Subject: RE: Y/9818/RES and Y/97/18/DOC

I am a landscape architect involved in the above scheme. I am writing in response to the latest comment from the drainage officer regarding proposed trees being in close proximity to the attenuation tanks.

BOVIS HOMES
scheme: Land off Burndell Road Yapton
client: Bovis Homes
drawing: Hard Landscape Proposals
date: Nov. 2018
scale: 1:200@A1
drawing no: BOV22172 12E sheet 4
drawn: AE checked: DKM

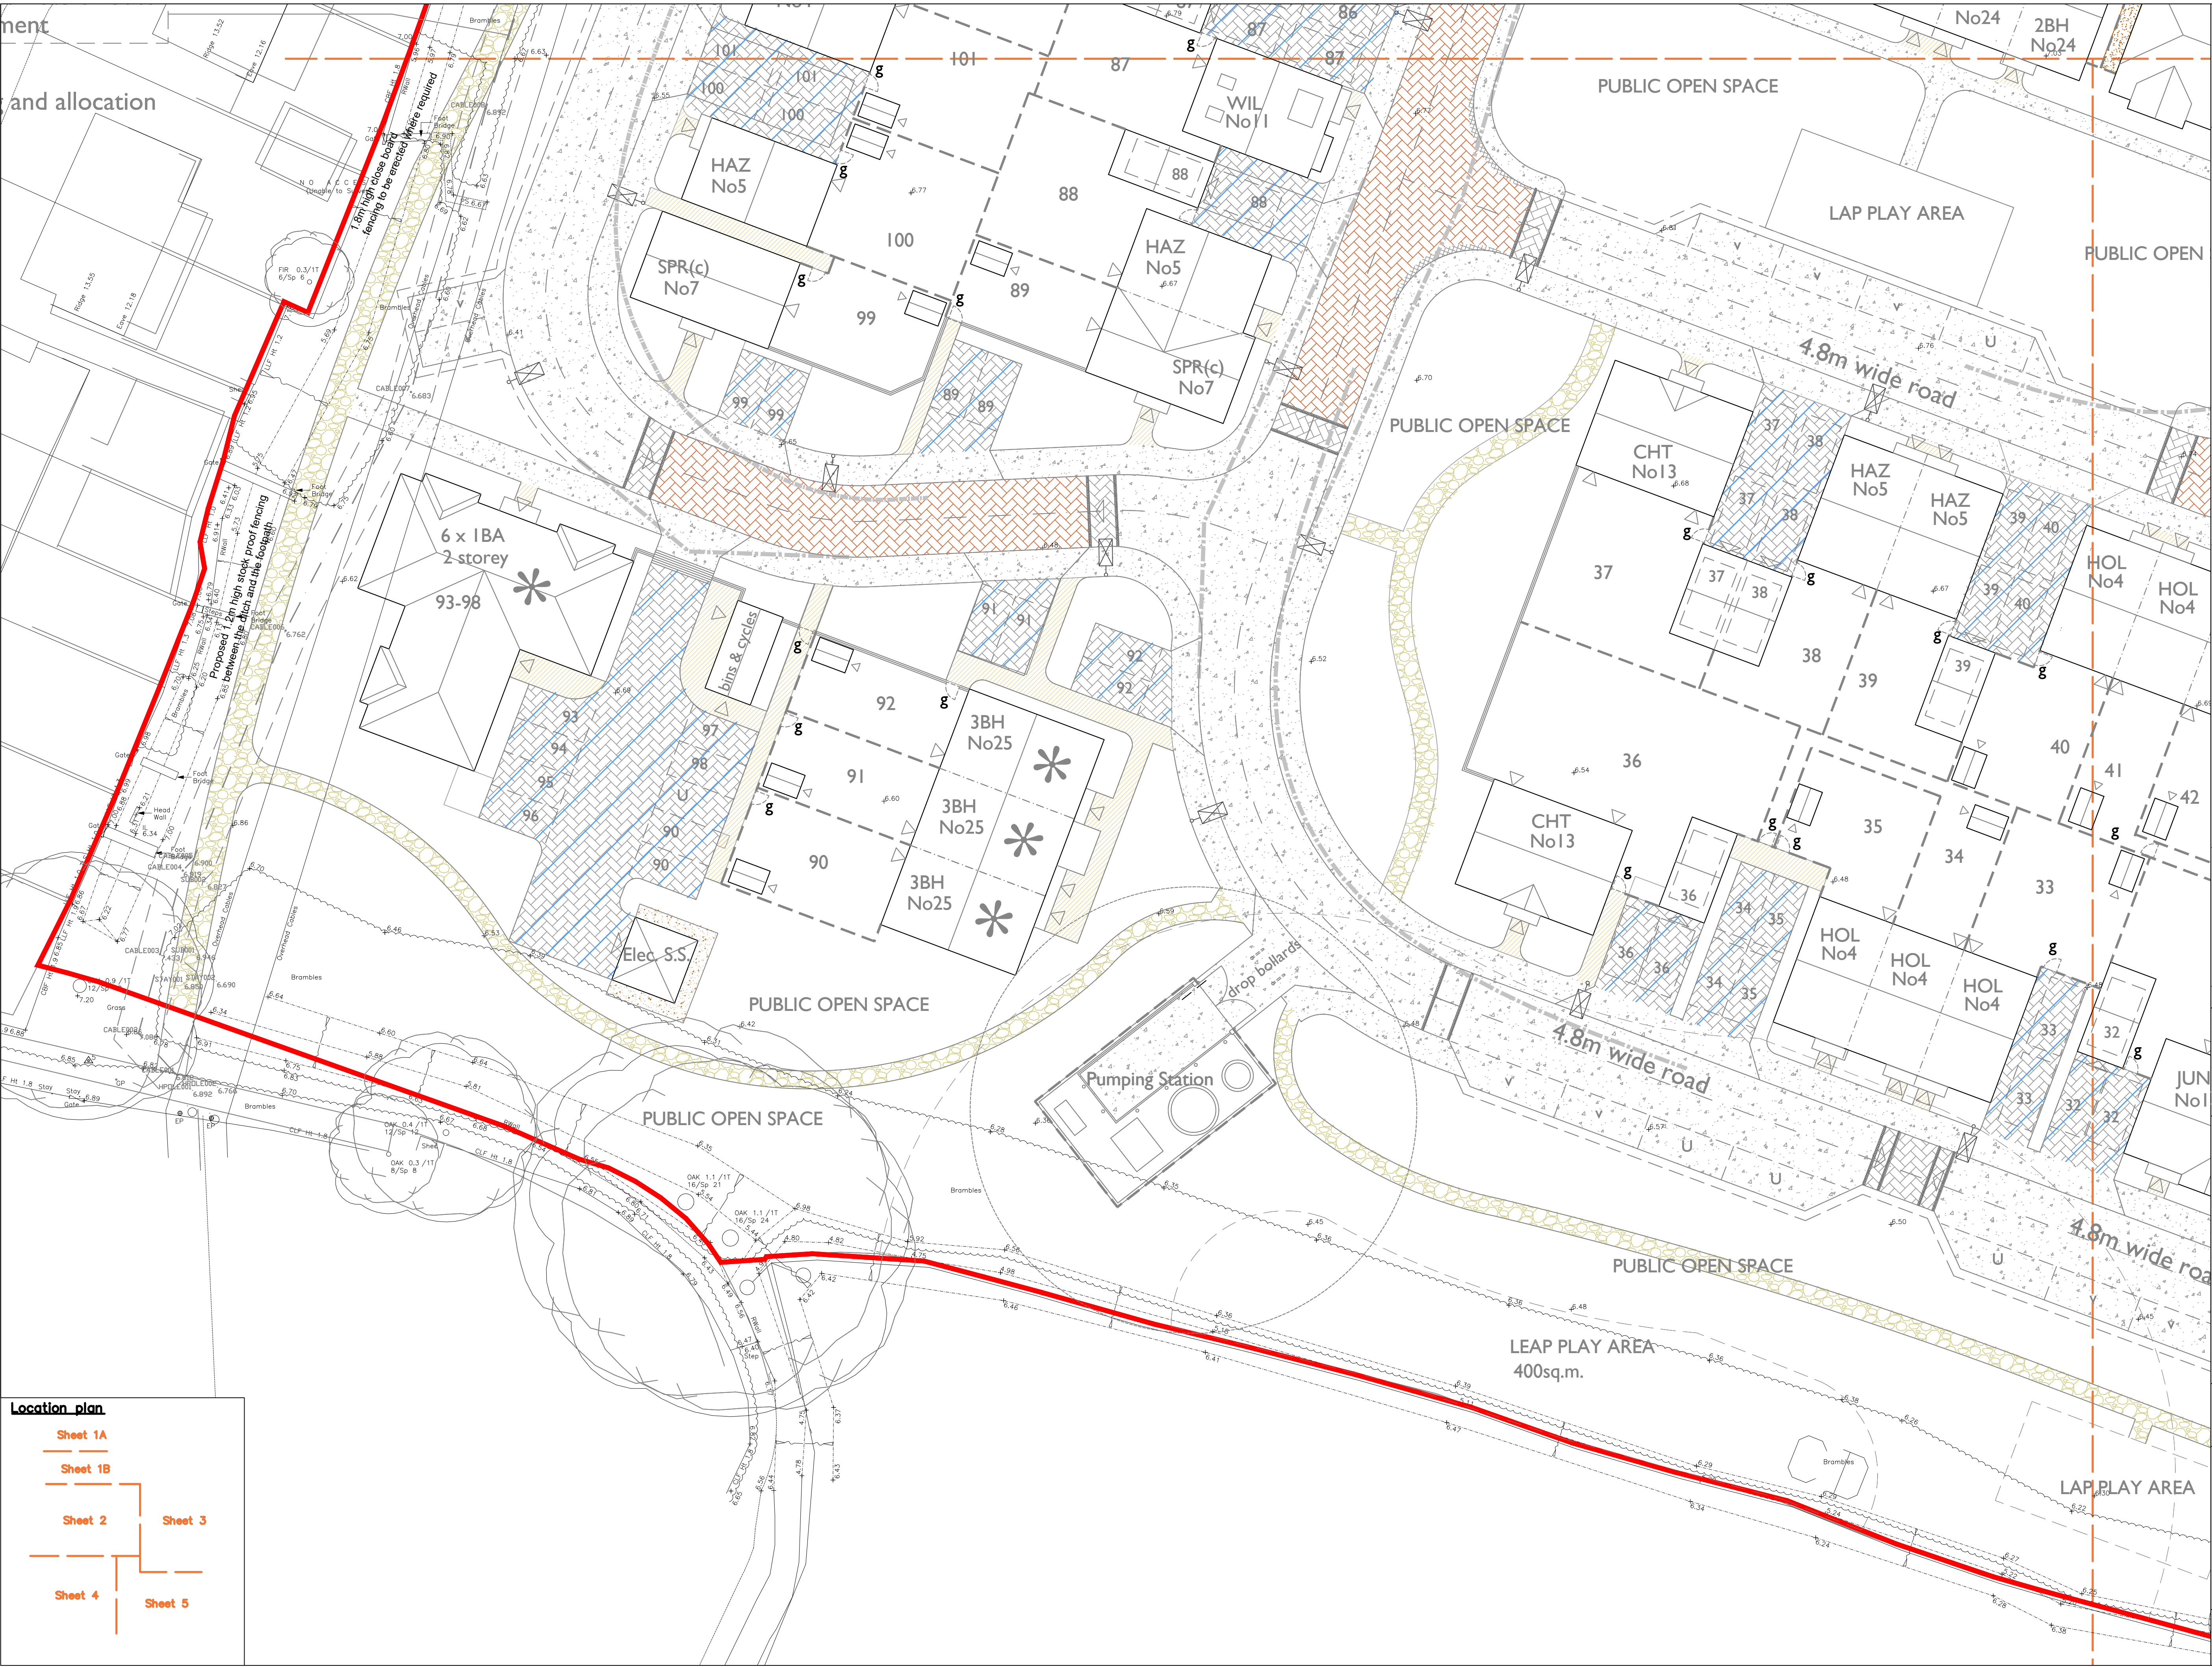
I would be grateful if you could ask your colleague to provide further clarification as all proposed trees are shown outside the 5m buffer. Also, we have relocated/removed all proposed trees in proximity to the attenuation pond.

There are still trees located in close proximity and in some instances over the attenuation tanks. These need to be removed. Attenuation tanks must not conflict with potential root areas of proposed trees.
